Application No: EP/68/21/HH
Site Address: Merrydown Kingston Lane East Preston BN16 1RP
Description of works: Erection of timber framed detached garage with ancillary accommodation on first floor, installation of electric gated entrance, erection of new brick garden walls and extension to existing driveway and hardstanding.

OWQC38882

As the property is within the Elm Avenue, Golden Avenue (part), Kingston Lane (part) North Lane (part) East Preston Area of Special Character, the committee agreed to object to this Application on the following grounds.

East Elevation 1:50

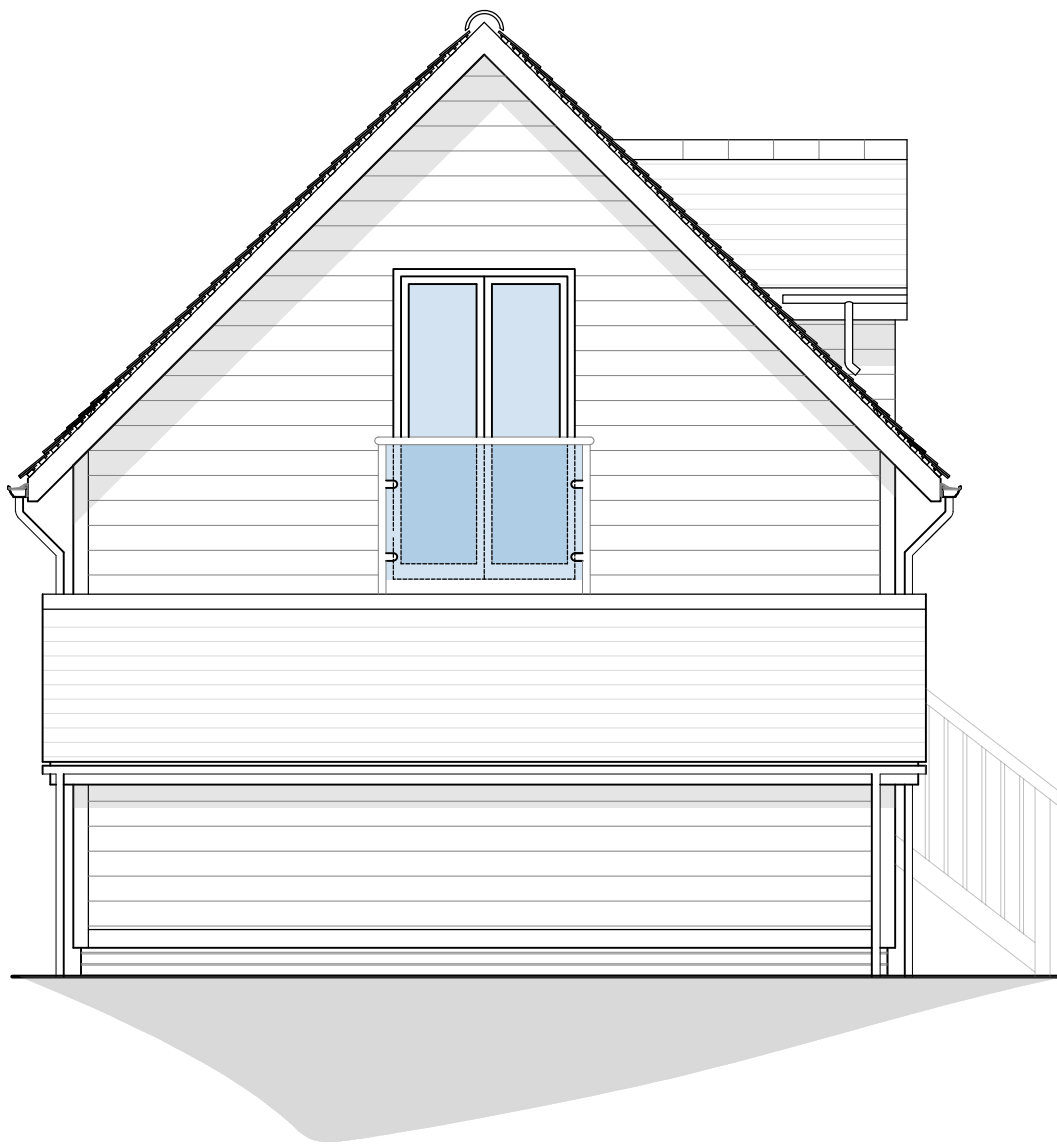
1. The proposed garage is deemed to be too close to the front boundary and would be better sited further back, at least to be in line with the eastern elevation of Oakcroft to the south. This would address the comment in the description of the Area of Special Character, There is a regular building line .

2. The proposed gate is very solid and not in keeping with the semi-rural setting of this property.
3. The proposed use of slate on the garage roof is out of keeping with the earth-tones palette of materials on nearby buildings and possibly also contrary to the semi-rural setting of this property.
